SCOPING OPINION:

Proposed Theddlethorpe Flexible Generation Project

Case Reference: EN0110008

30 October 2025

Figure 2: Designations

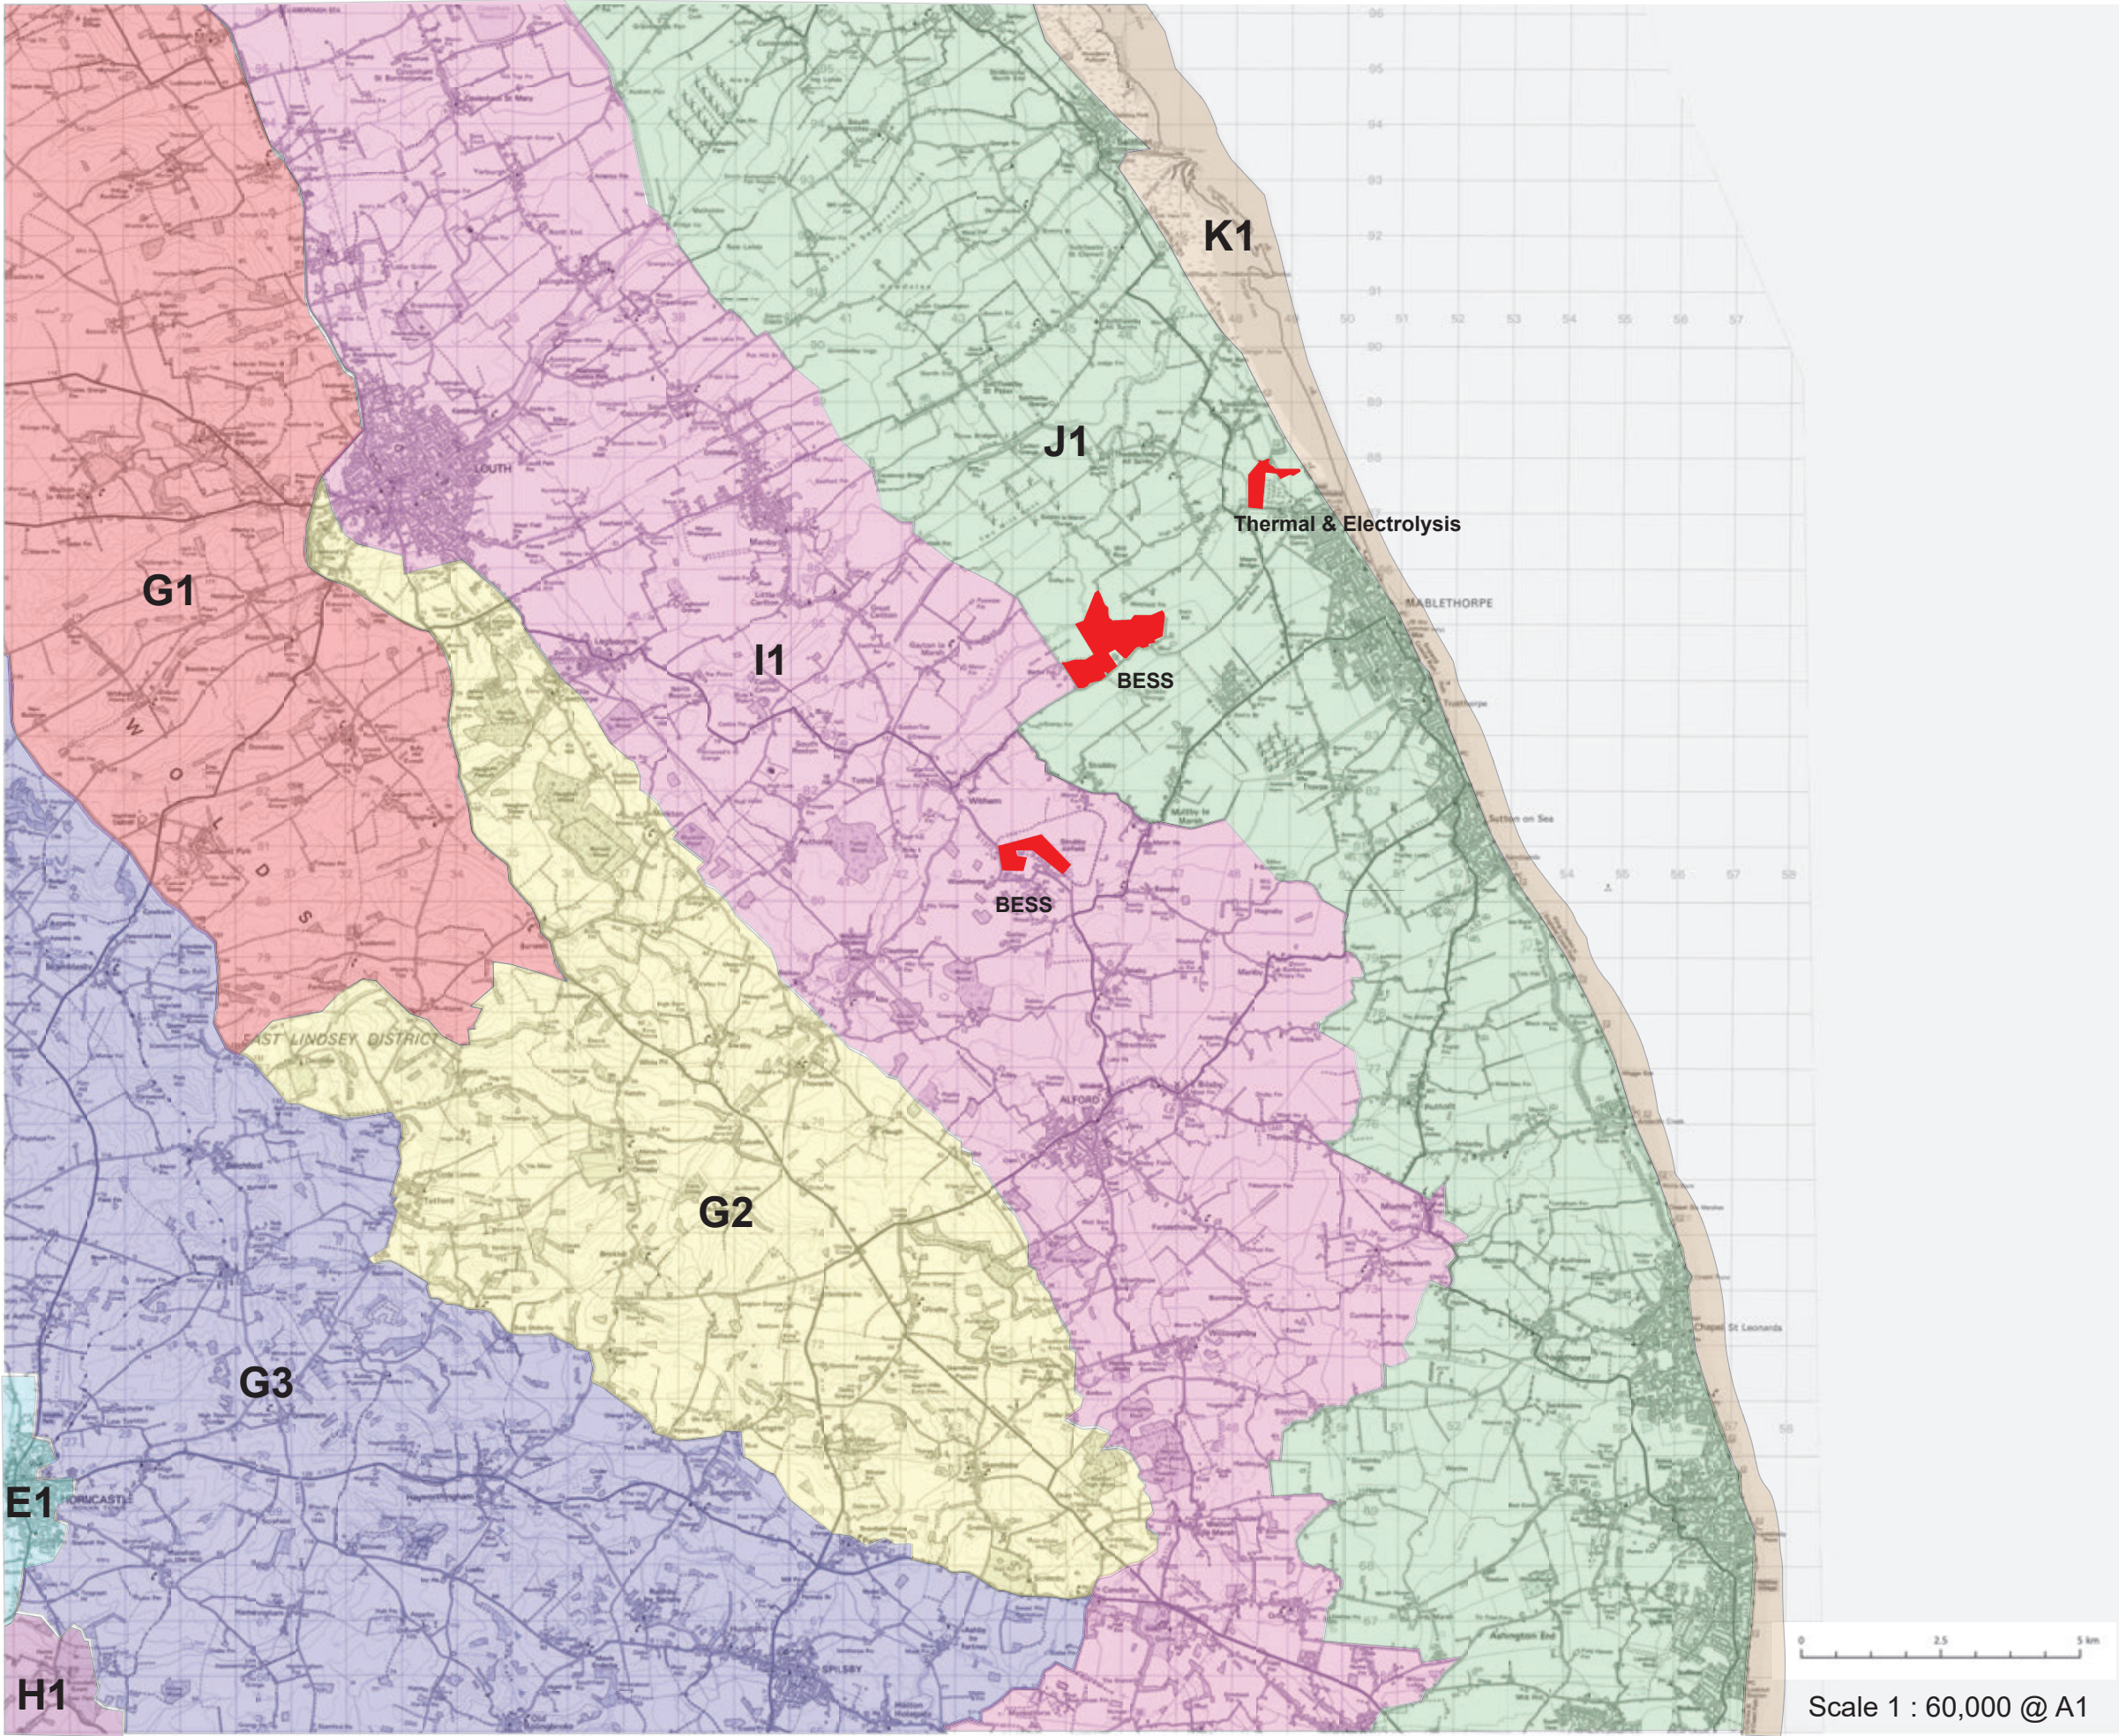
ID	Ref	Description	Inspectorate's comments
			development consent to decide whether it is satisfied, given the nature of the project in question, that it has 'full knowledge' of its likely significant effects on the environment."
212	Figures 4-1, 4-2, 5-9 and figure 2 of appendix E	Figures	The Inspectorate notes that some of the figures provided as part of the Scoping Report are of low resolution, making them difficult to read, in particular figures 4-1, 4-2, and figure 2 of appendix E. Figure 5-9 is also of low resolution and the labels are not particularly clear. The applicant should ensure that all figures in the ES are clear and features on the figures are clearly discernible.
213	Paragraphs 5.1.3 and 5.5.57	Connection to the proposed National Grid Lincolnshire Connector Substation A (LCS A)	The Scoping Report states that there may be the need for some ancillary connecting works at the proposed substation to facilitate the project linking to LCS A, which is proposed as part of the National Grid Grimsby to Walpole connection project. The ES should describe the relationship between the proposed development and any connected projects, such as LCS A, including the use of figures. This should include the extent to which the proposed development is dependent on their delivery and the development timelines of other projects (including the predicted lifespans once operational), with an explanation of how these will be coordinated to reduce environmental effects. Any assumptions made about connected projects should be explained, together with any uncertainty remaining and how this is addressed in the assessment.
